CITY OF ALBUQUERQUE

August 14, 2008

Re: Approval of Temporary Certificate of Occupancy (C.O.) for
Cibola Energy Corp. Office Remodel, [J-13 / D090]
1429 Central NW
Architect's Stamp Dated 08/07/08

C101

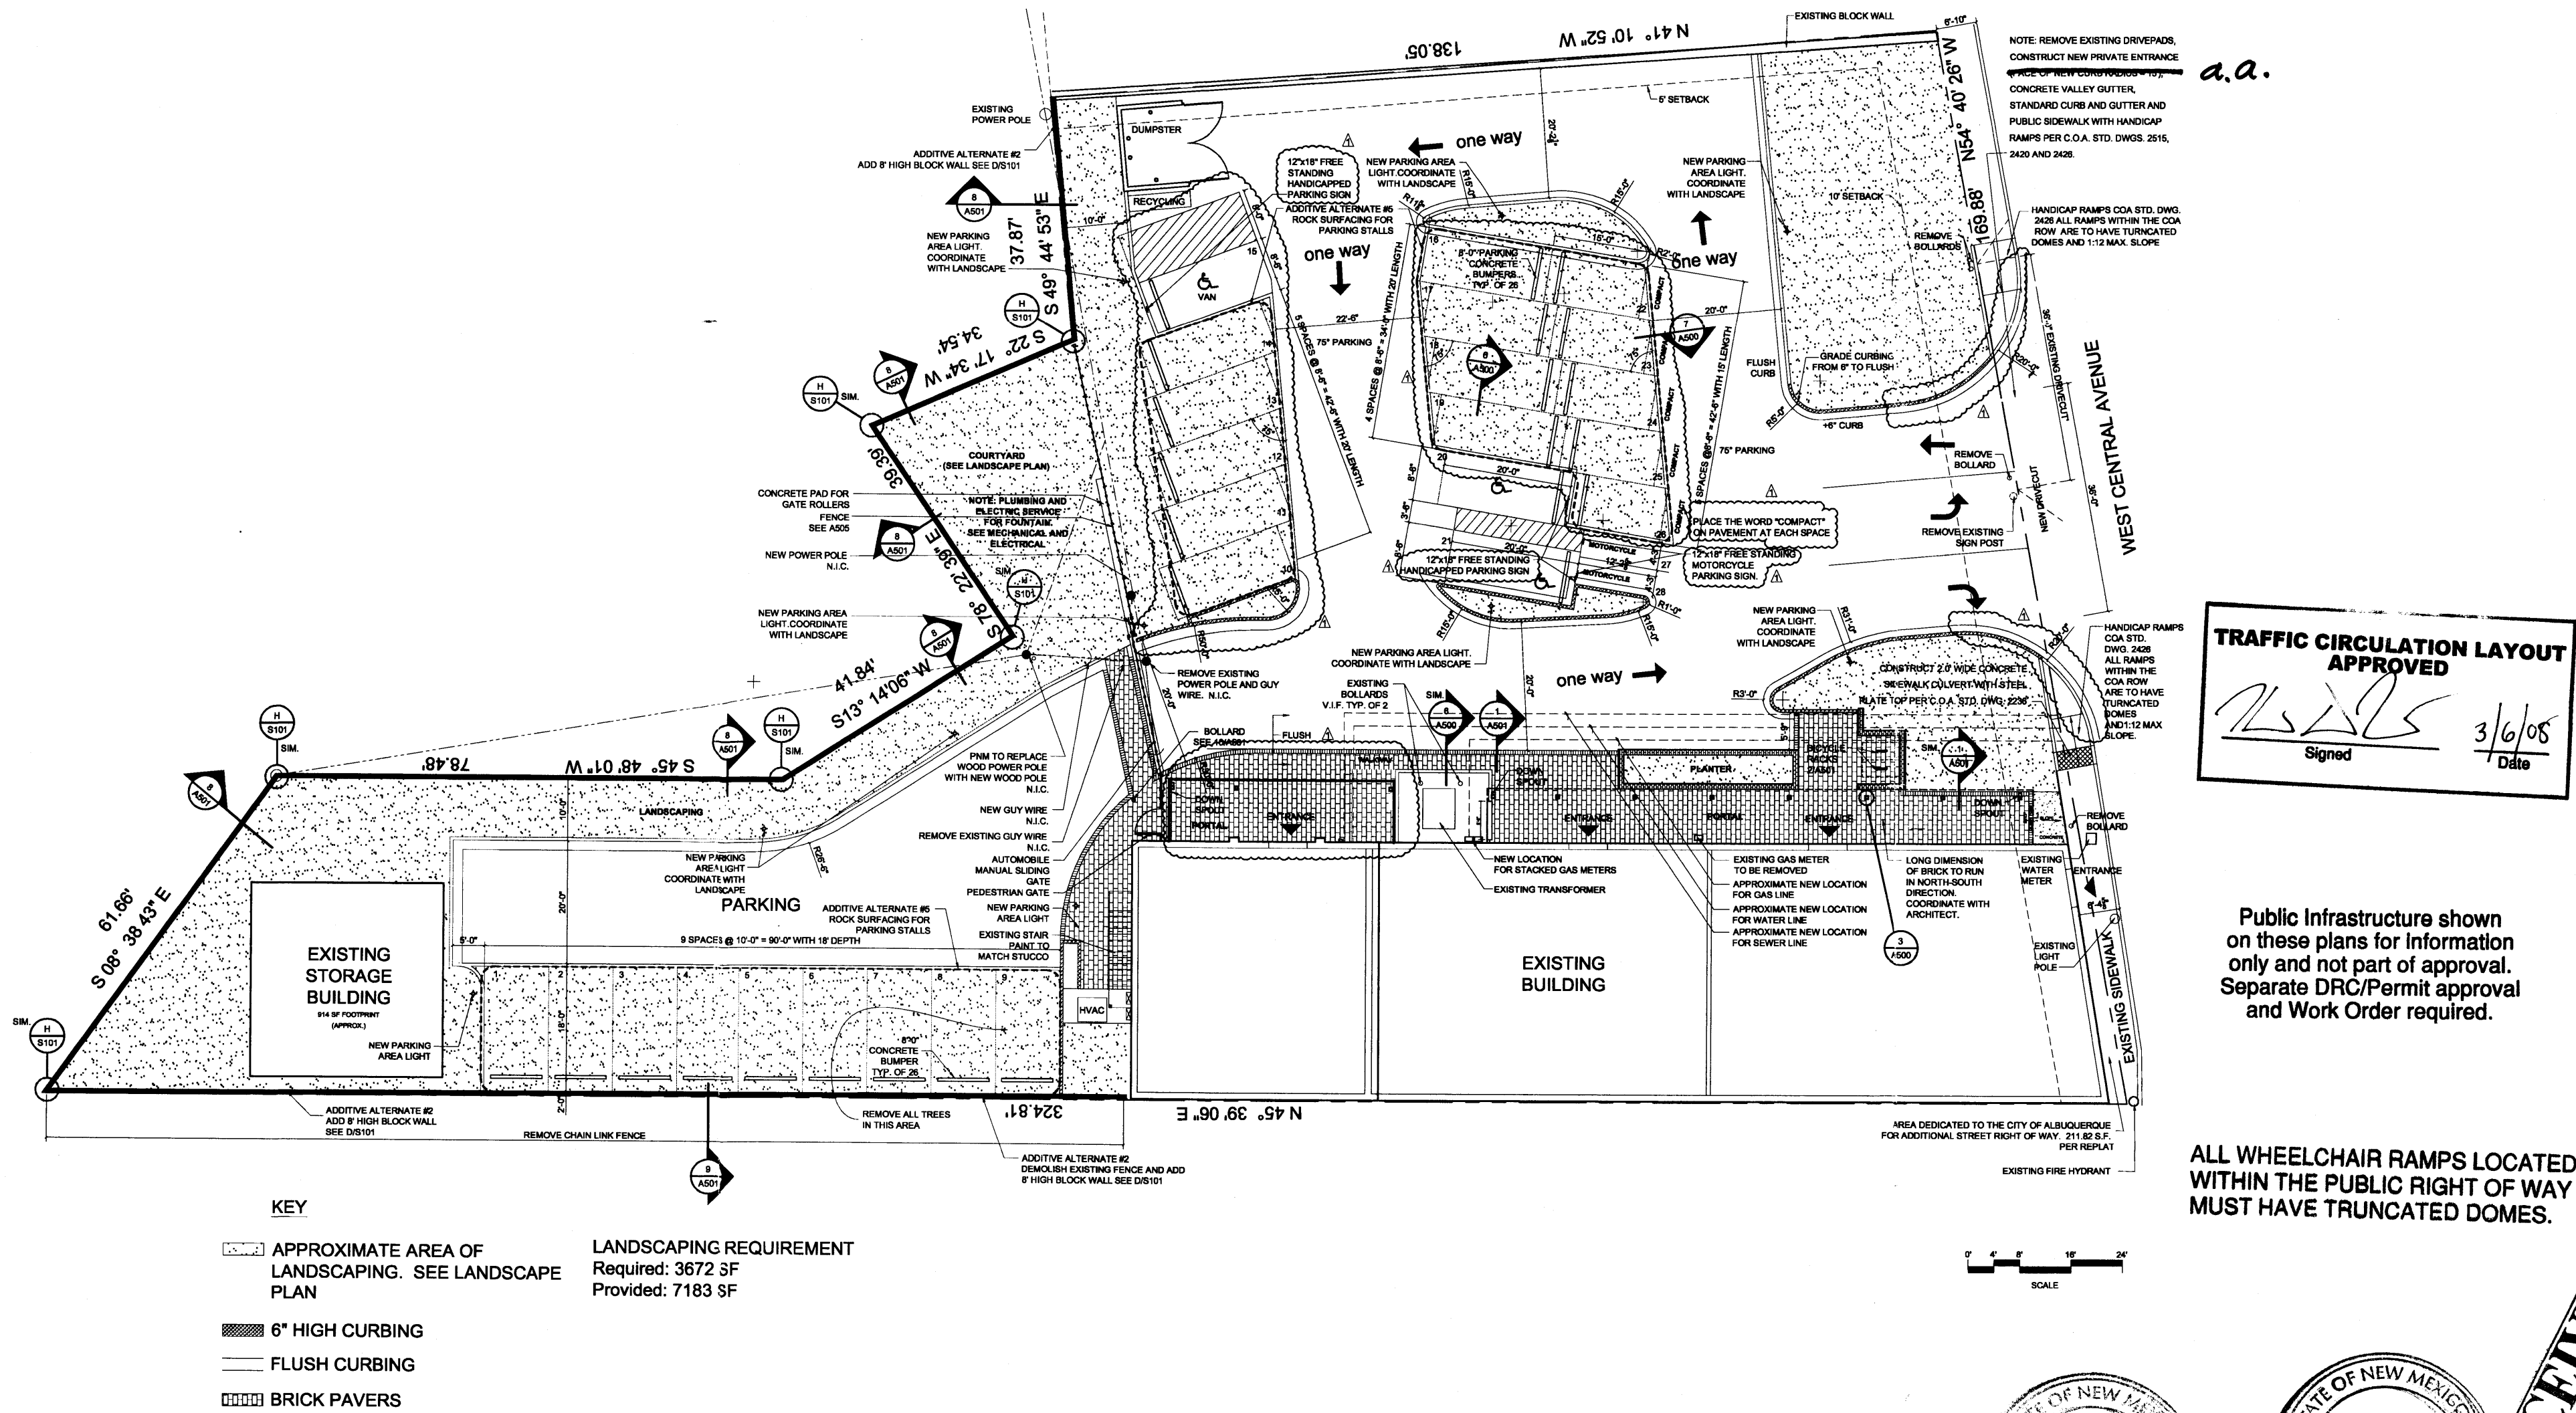
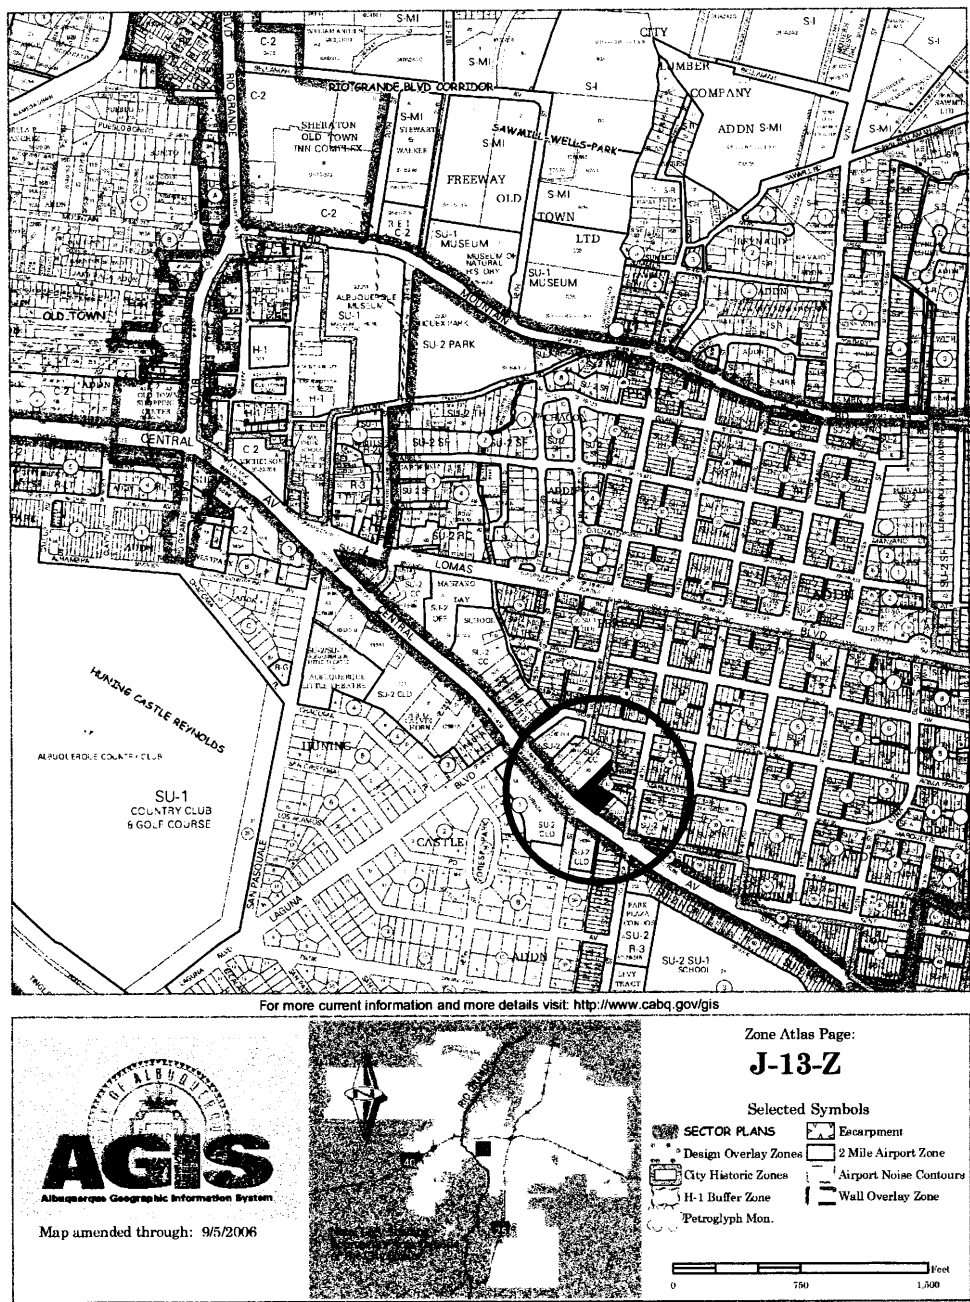
A Temporary C.O. has been issued allowing the outstanding radius (entrance radius is called out as 20' and 15', please clarify with redlines on which radius was actually construct at entrance) issues to be completed within this time period. When these remaining issues have been fully completed, are in substantial compliance, and a final Certification for Transportation has been resubmitted to the City's Hydrology office for approval, a Permanent C.O. will be issued.
